Re: Application 2023/93206 - Erection of single and two storey extensions and raised patio to existing dwelling and detached garden building.

Project: ANNEX PROPOSED PLANS

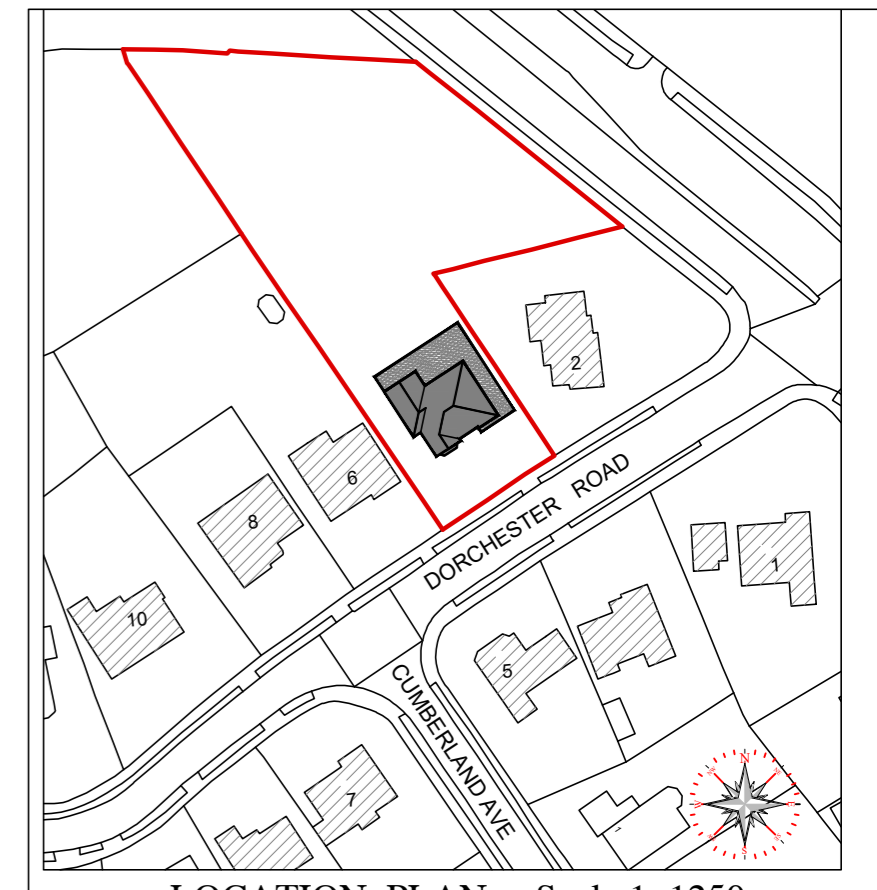
My concerns are two-fold. Firstly, there is very little detail about the floorplan of the proposed annex and indication of what purpose it will serve. The boundaries of this lie less than a metre away from our fence. On the corner of the fence sits a weeping willow which forms the main character feature of our back garden. The roots of this mature willow tree will extend far and deep into the applicant's garden as willows are known to have vast roots, up to 40 metres wide. The proposed annex will inevitably damage the roots of this tree which may cause it to die, and in the worst case scenario, pose a danger to my own property. The applicant doesn't seem to have made any provision for the protection of trees in their proposals. I have little objection to the applicant erecting an annex at any other site on their vast garden well away from our boundary fence and willow tree. See figures 1 & 2.

PROPOSED GROUND FLOOR PLAN Scale 1: 100

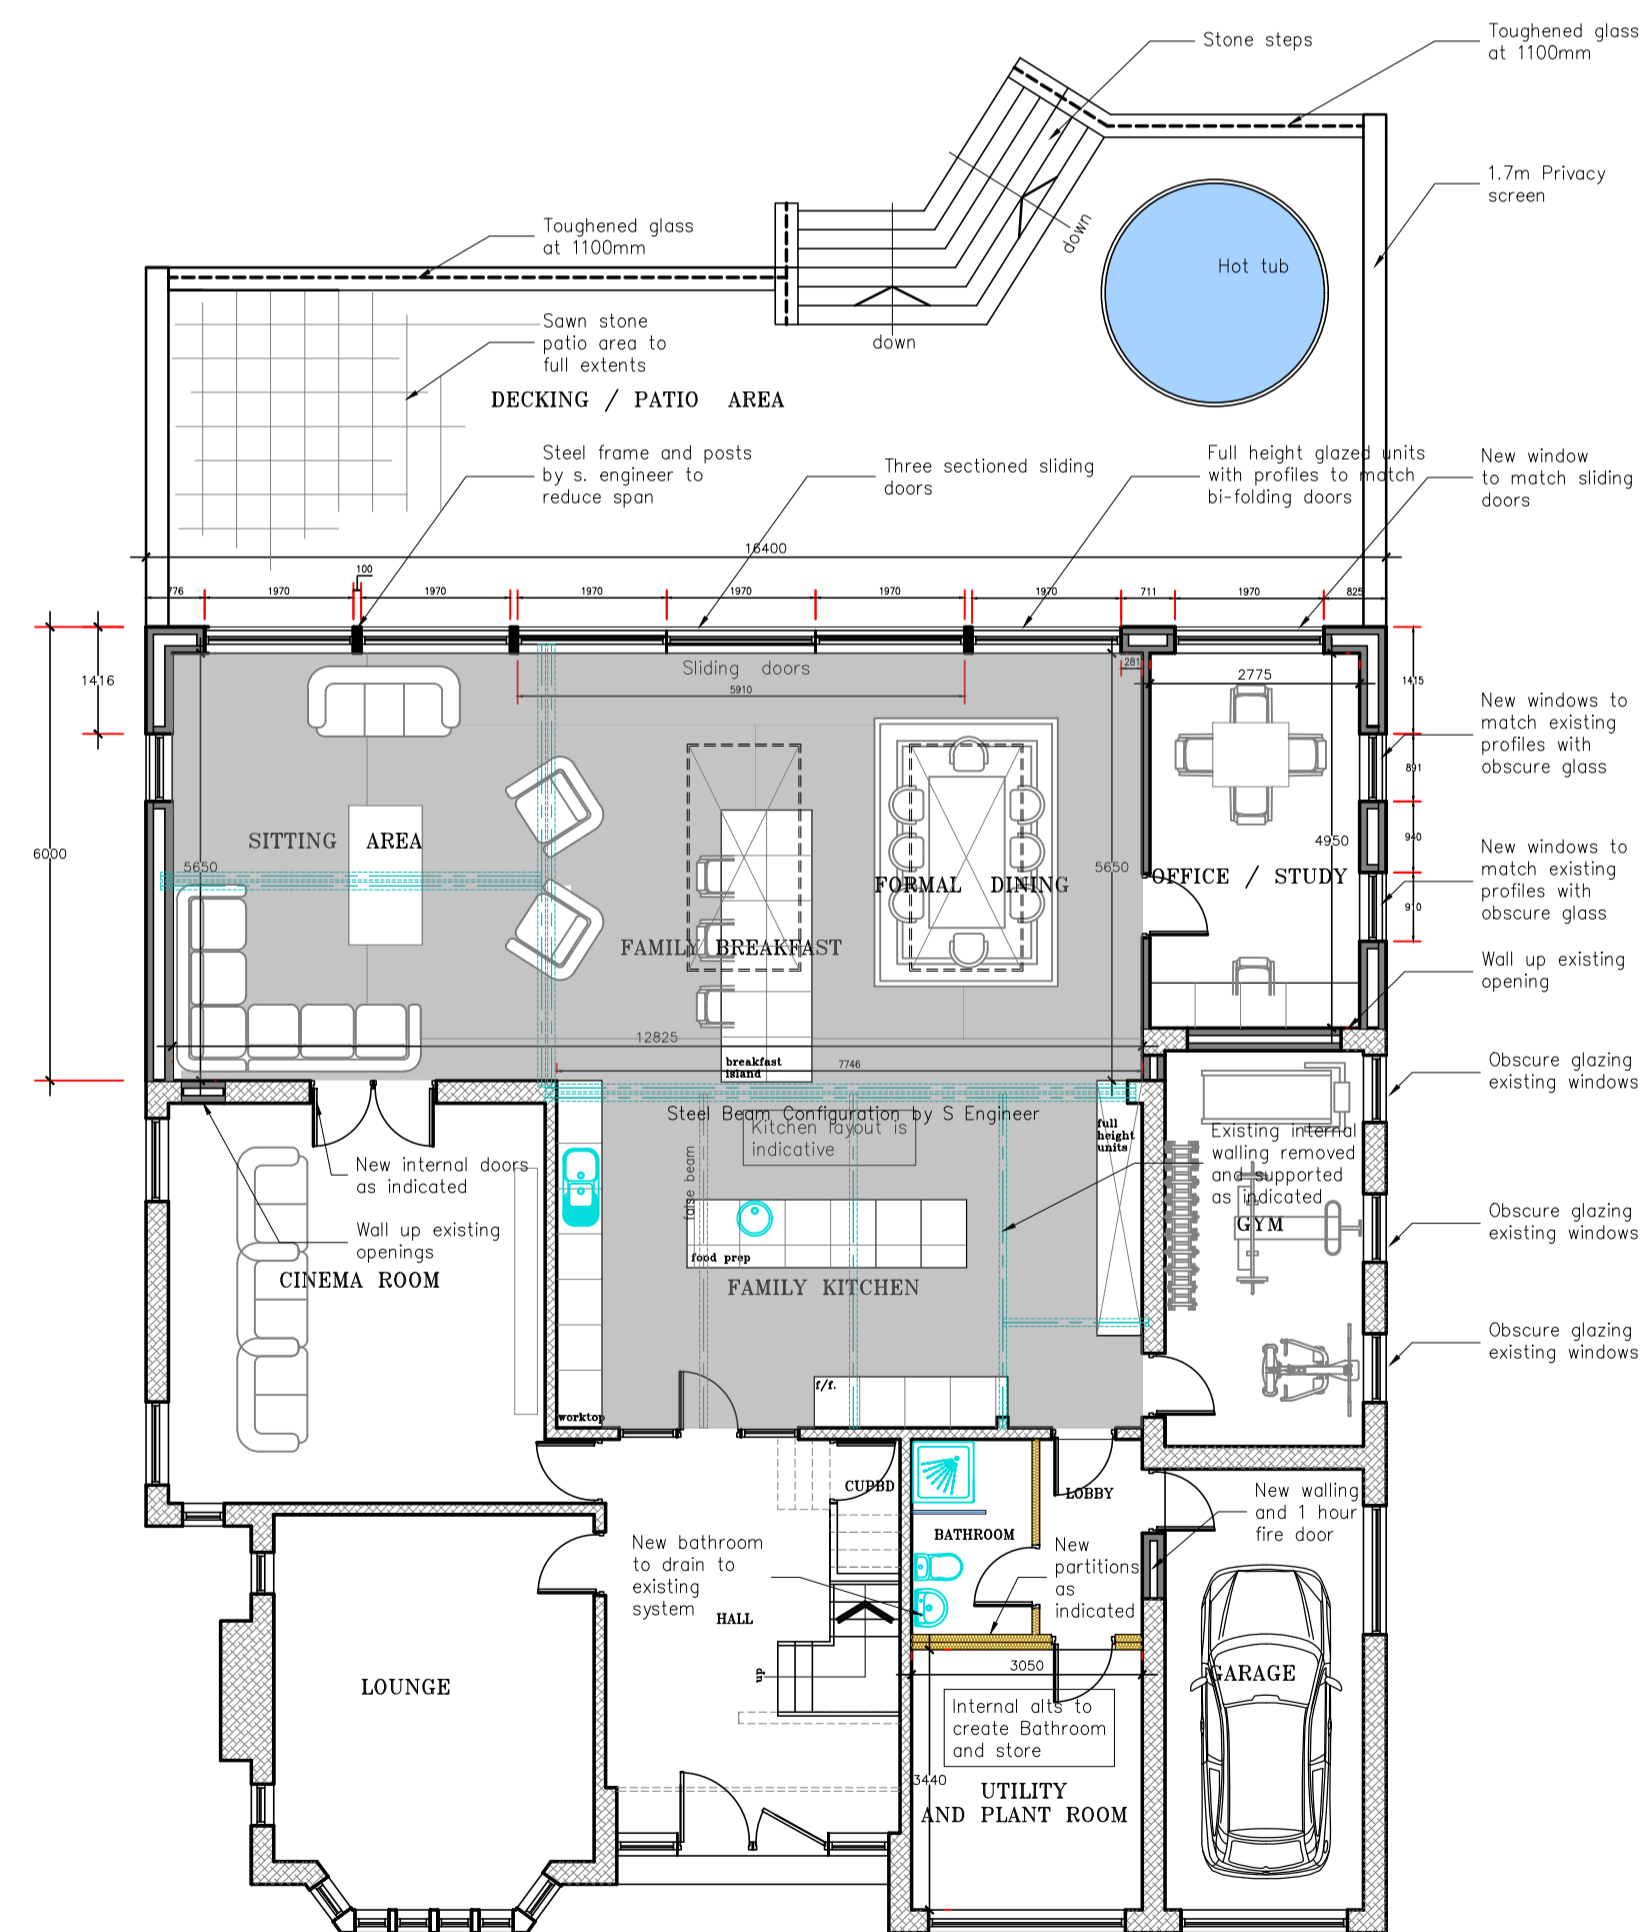
Again, the proposed extension to the back lies very close to our fence where another tree stands (in addition to the willow). I am concerned about whether this could also be damaged in the process of digging the foundations. The previous extension at the back already has windows facing into our garden impeding privacy. A further extension to the back will add further to the view of our garden from 4 Dorchester Road. See figures 1, 2, 3 & 4.

**Figure 4: Proposed plans showing proximity of trees and privacy at risk.**
